**Our Case Number:** ABP-314724-22

**Re:** Railway (Metrolink - Estuary to Charlemont via Dublin Airport) Order [2022]  
Metrolink. Estuary through Swords, Dublin Airport, Ballymun, Glasnevin and City Centre to Charlemont,  
Co. Dublin

**Observation; TII “Railway (Metrolink-Estuary to Charlemont via Dublin Airport) Order 2022”**

<b>RAILWAY WORKS</b> <b>METROLINK - PROPERTY DETAILS</b> <b>DUBLIN AIRPORT (SHEET 3 OF 5)</b>					
DRAWING NUMBER: ML1-JAI-BOR-ROUT_XX-DR-Y01034					
DRAWN: TW		CHECKED: MM		APPROVED: PB	
SCALE: 1:1000 @ A3		REVIEWED: AS			
AREA NUMBER: 302		PLAN NUMBER: ML-P 302 D-E		SUBJECT: PROPERTY

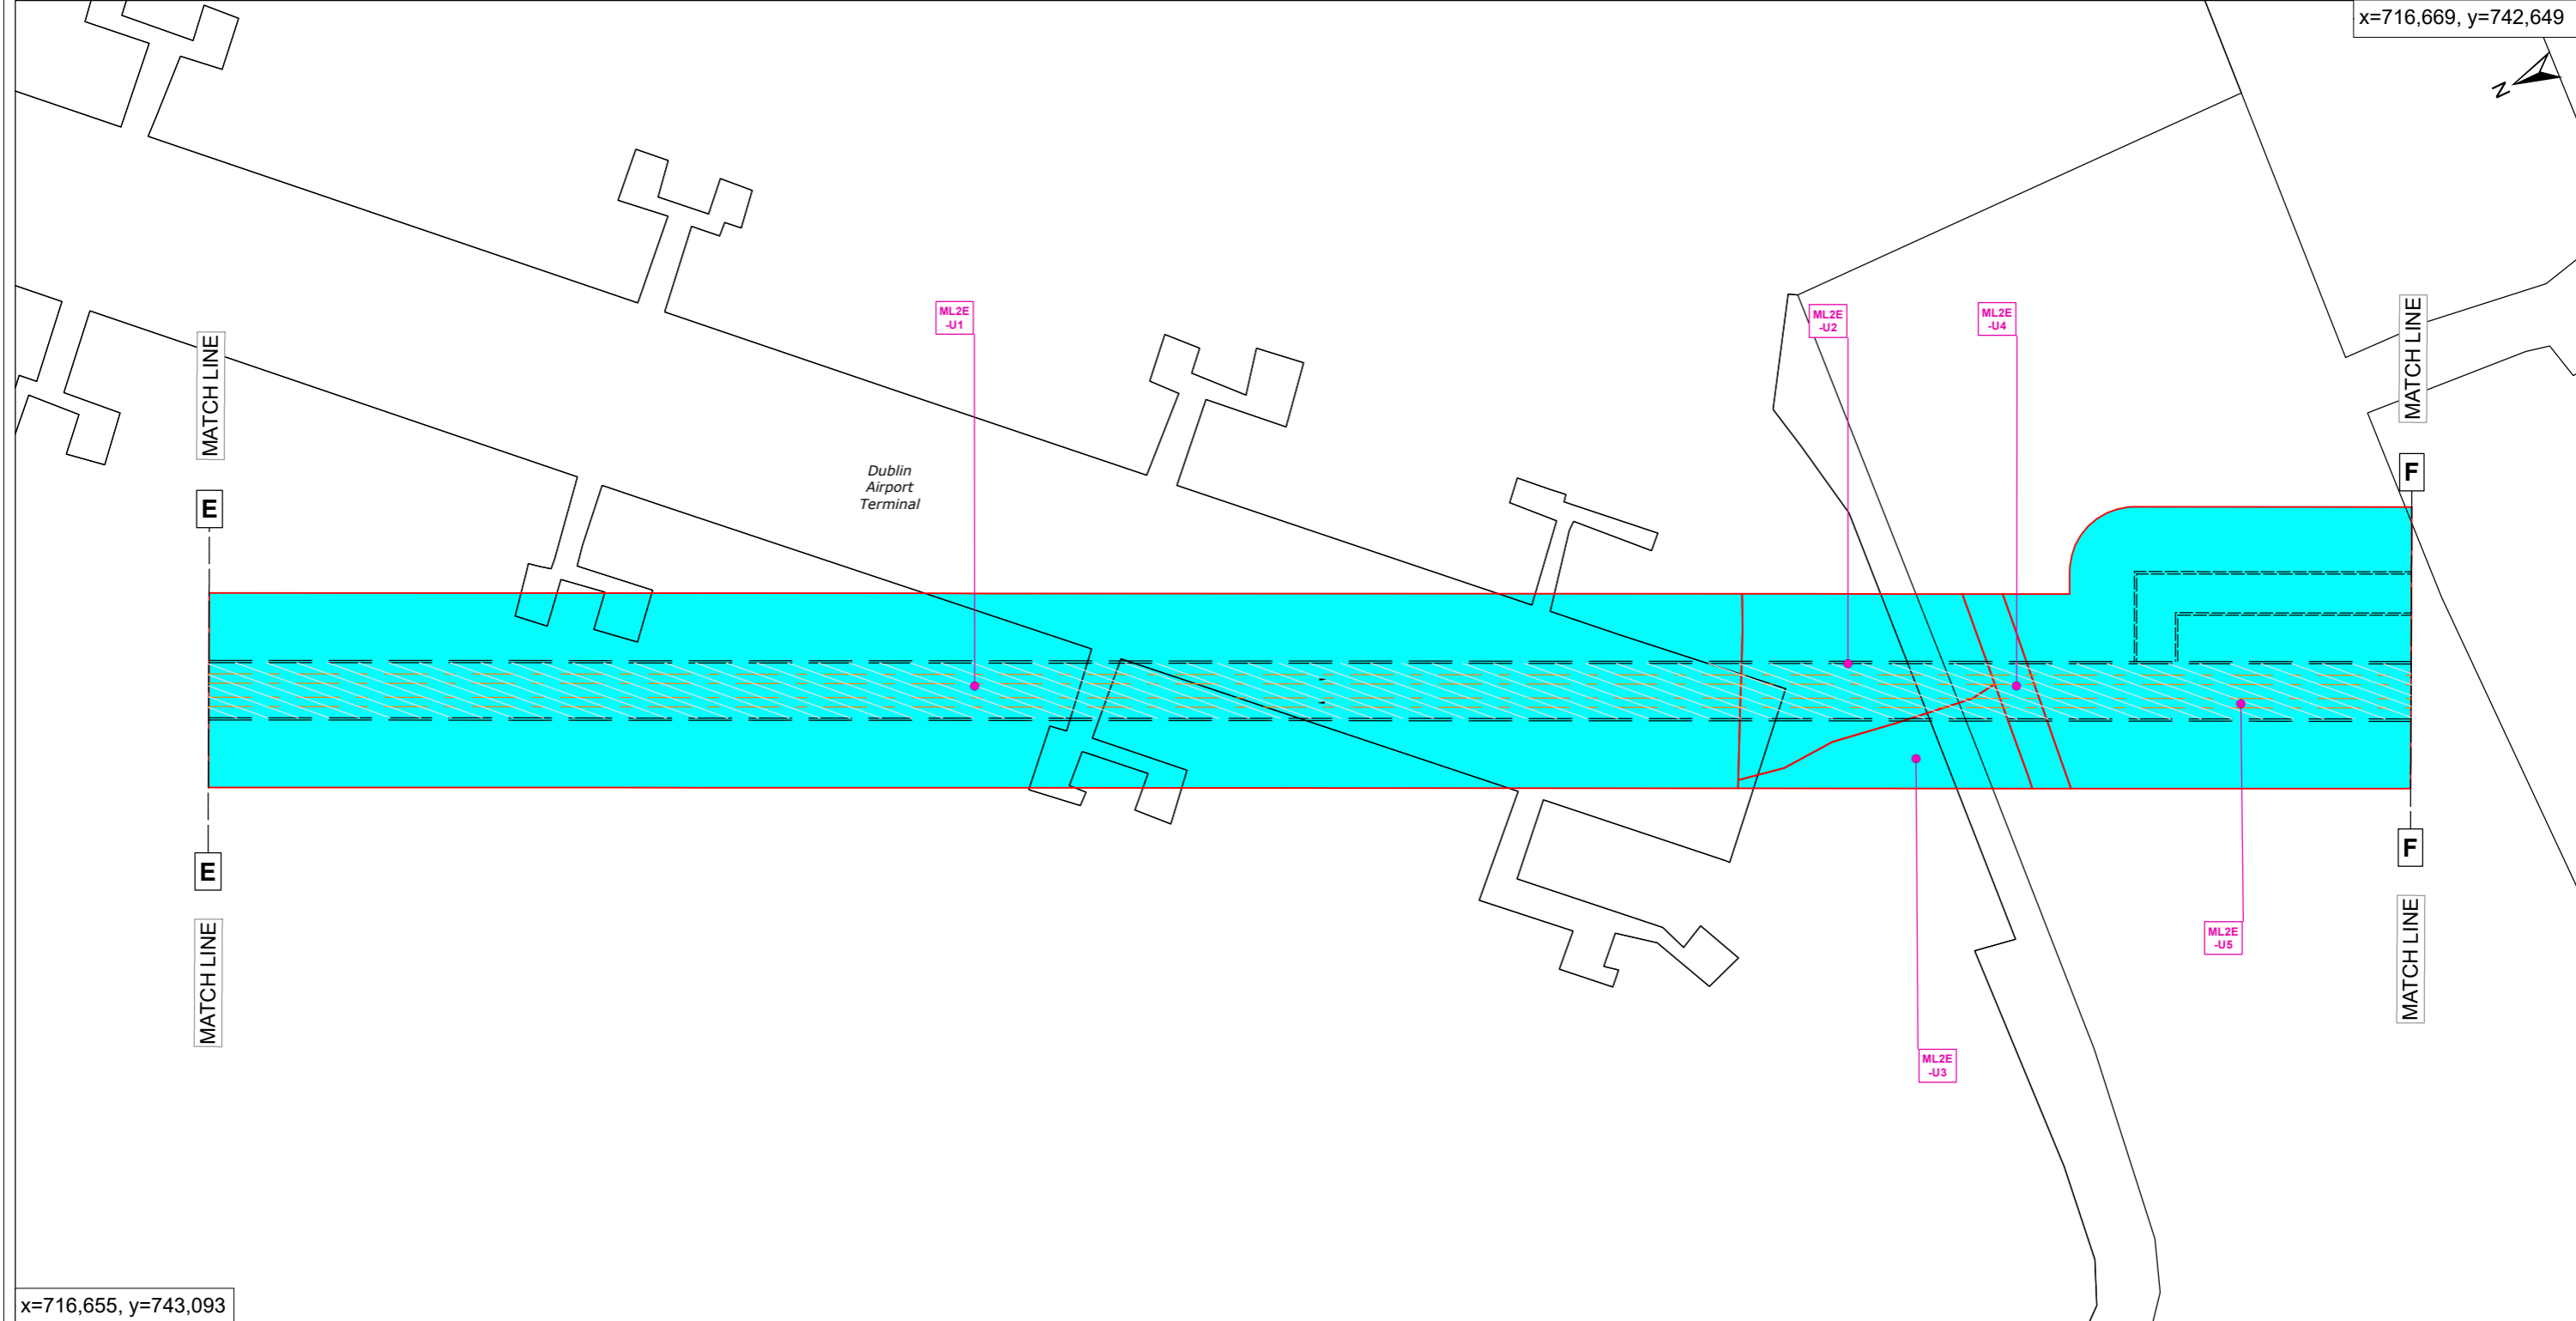
We refer TII and ABP to Alignment Drawing ML-RO-302 D-E specifically cross section drawing AA.

Similar to Zurich Airports APM design, in order to ensure a subterranean APM station box between T1&T2 at LEVEL-1 (perpendicular to and on top of the Metrolink line) we request that ABP safeguards this critical future APM. TII could therefore be asked to deepen the southbound tunnel (from the Dublin Airport station) towards section AA.
